Arun District Council
Arun Civic Centre
Maltravers Road
Littlehampton
West Sussex BN17 5LF
Planning & Building Control General Enquiries
Tel: (01903) 737756 Fax: (01903) 730442
Dx: 57406 Littlehampton
Minicom: 01903 732765
e-mail: planning@arun.gov.uk
website: www.arun.gov.uk/planning

Application No: BE/77/21/HH
Site Address: 19 South Way Bersted PO21 5HB
Description of works: Removal of 3 No existing lean-to structures & erection of single storey side & rear extensions, loft conversion to form new second floor with roof alterations to form gable end with rear dormer projection & detached outbuilding to be used as an annexe to the existing dwelling (resubmission following BE/37/21/HH).

Thank you for your internet representation made on 1st June 2021 which has been recorded as an objection with the comments as follows:

Ground floor plan
1 : 50

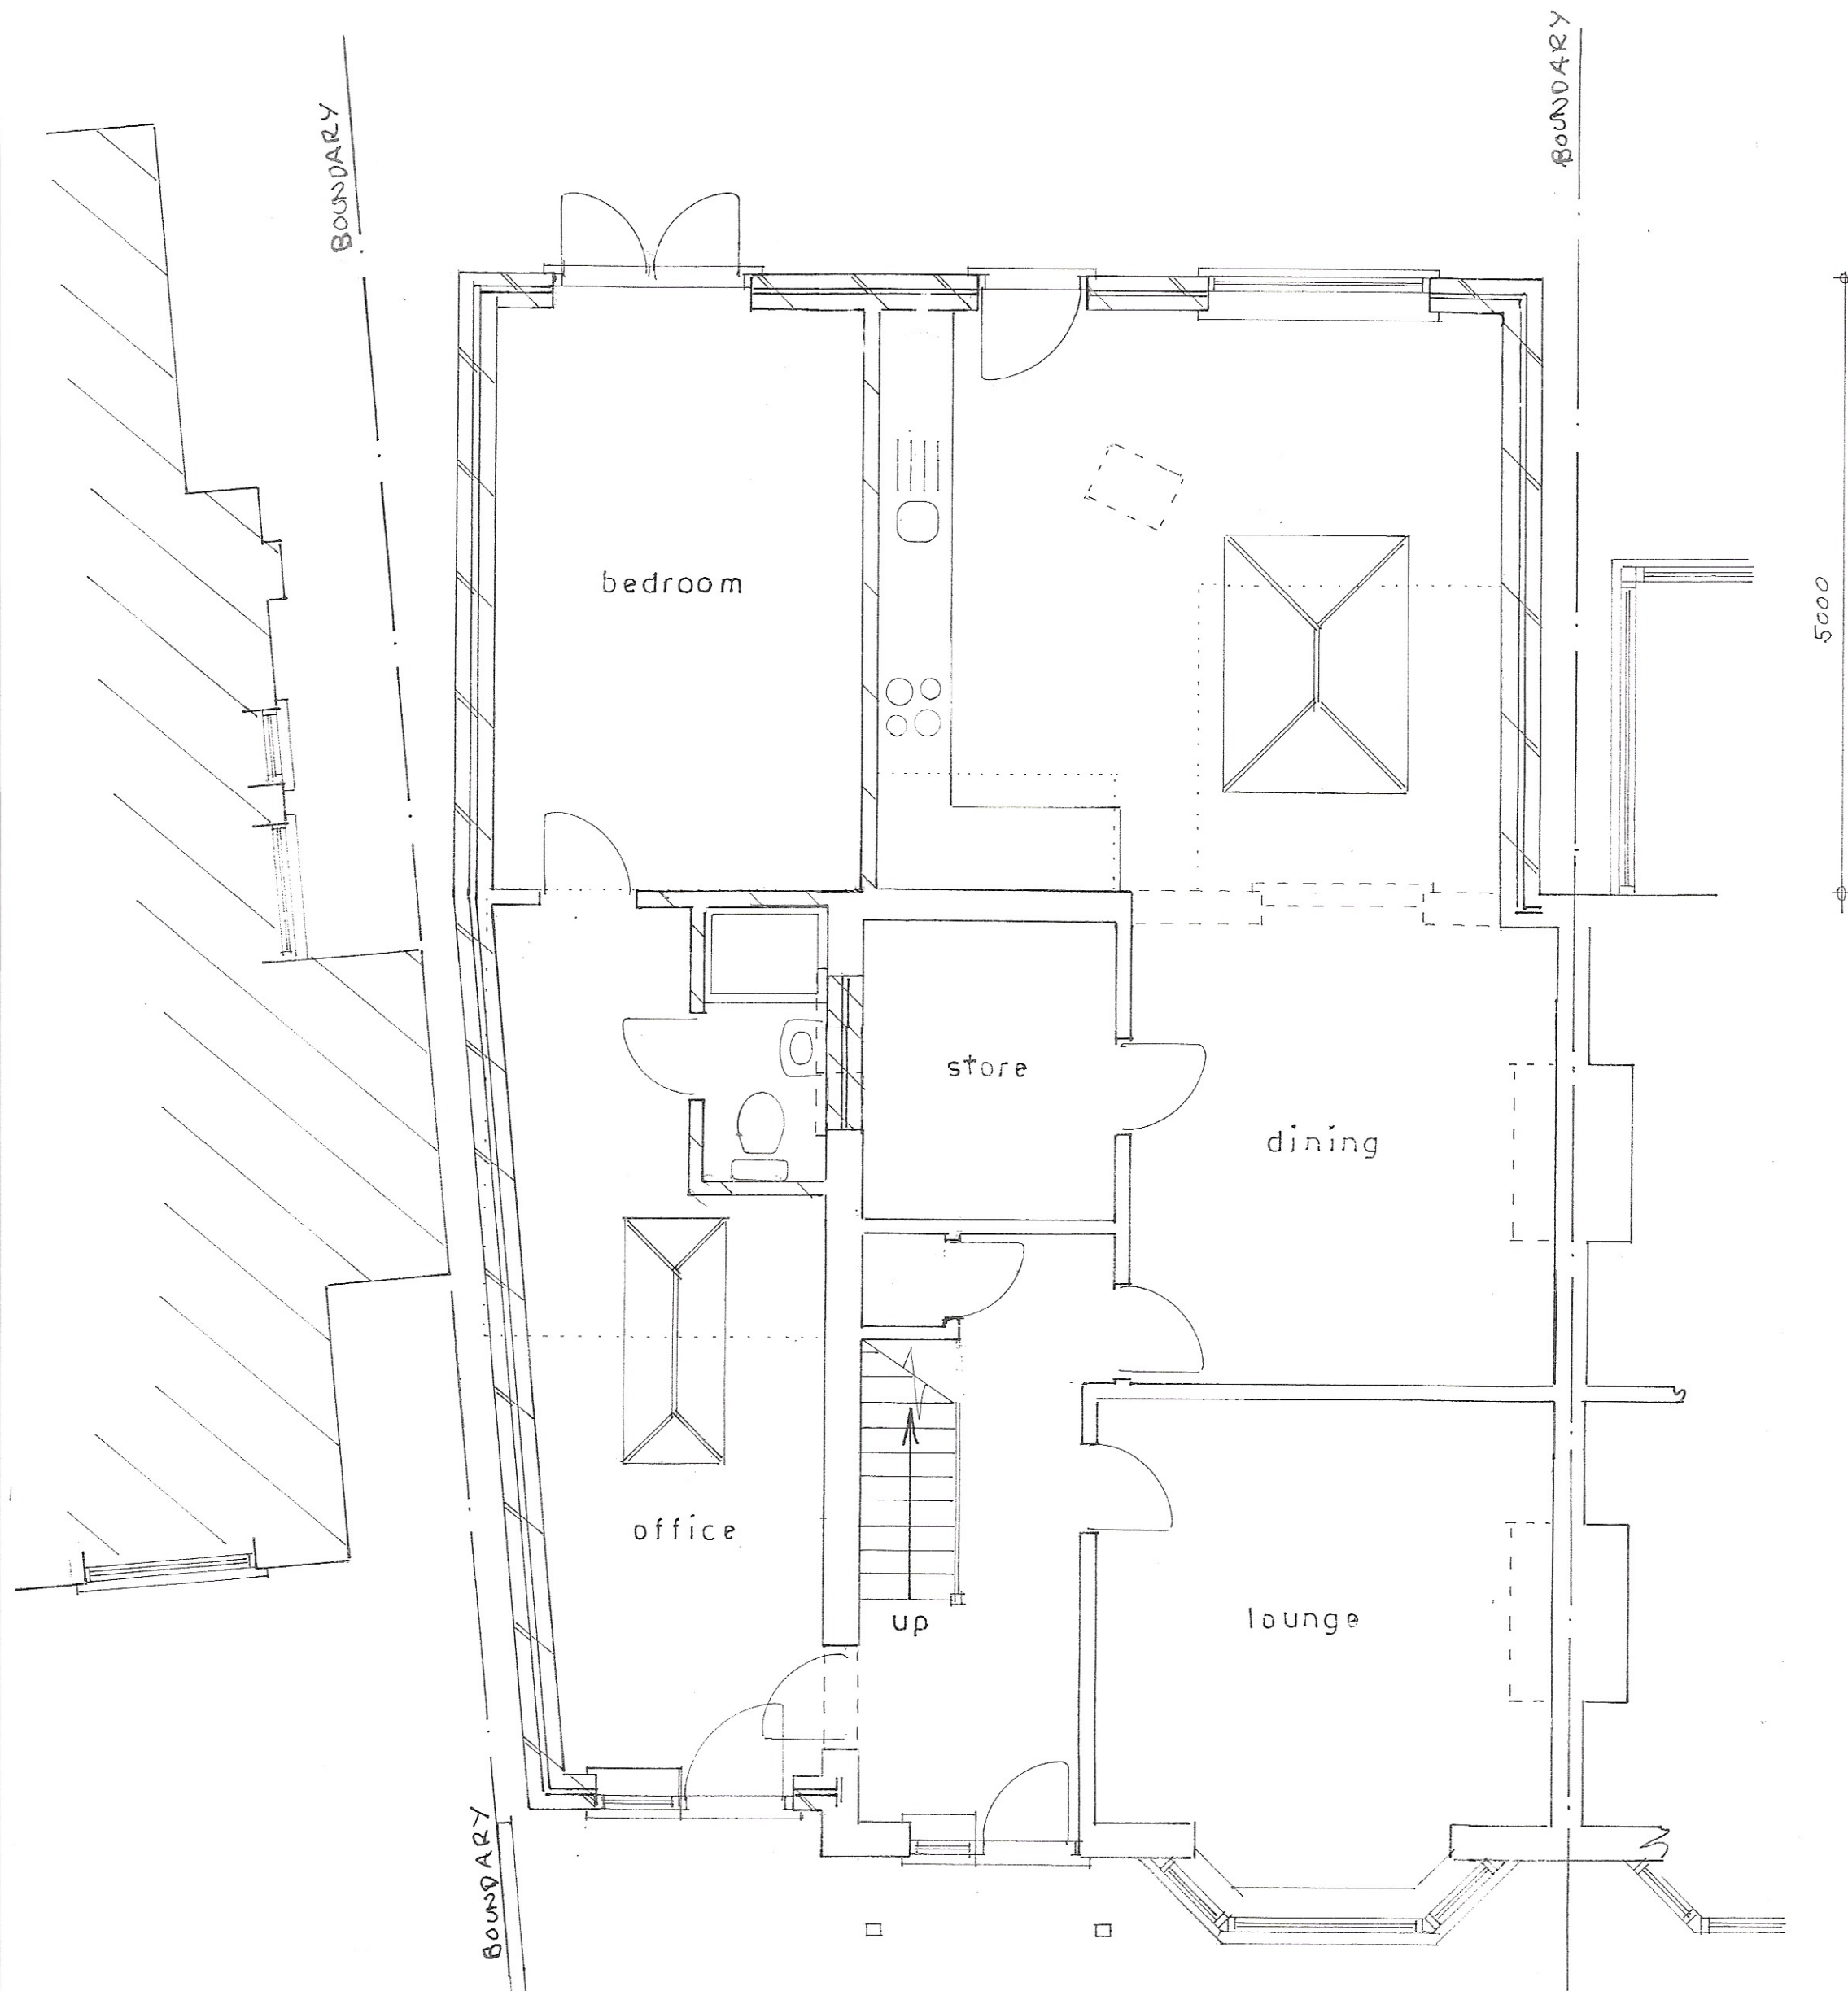
"The development will have a significantly harmful impact on the residential amenities of neighbouring dwellings due to its excessive scale in such close proximity to the Southern and Northern boundaries of the site. It will have, as a result, an overbearing impact on the occupiers of the property directly to the North, #17 South Way a single storey bungalow."

"The proposal does not show the addition of any parking to the dwelling. There is space for one car to the front of the site which would appear to be retained. The road is a busy road which has a lot of cars parked on the street. This is heightened during school pick up and drop off when the road has no available parking. The parking standards for a 7 bedroom house in zone 2 suggests that there would need to be a minimum of 3 parking spaces available. As such the scheme is not considered to meet with the parking demands of the area in conflict with T SP1 and the Arun Parking Standards."

"The rear extension and annexe due to the height, length and siting and size are overdevelopment resulting in an unneighbourly and unacceptable overbearing effect on the occupiers of 17 and 21 South Way contrary to policies D DM1 and D DM4 of the Arun Local Plan."
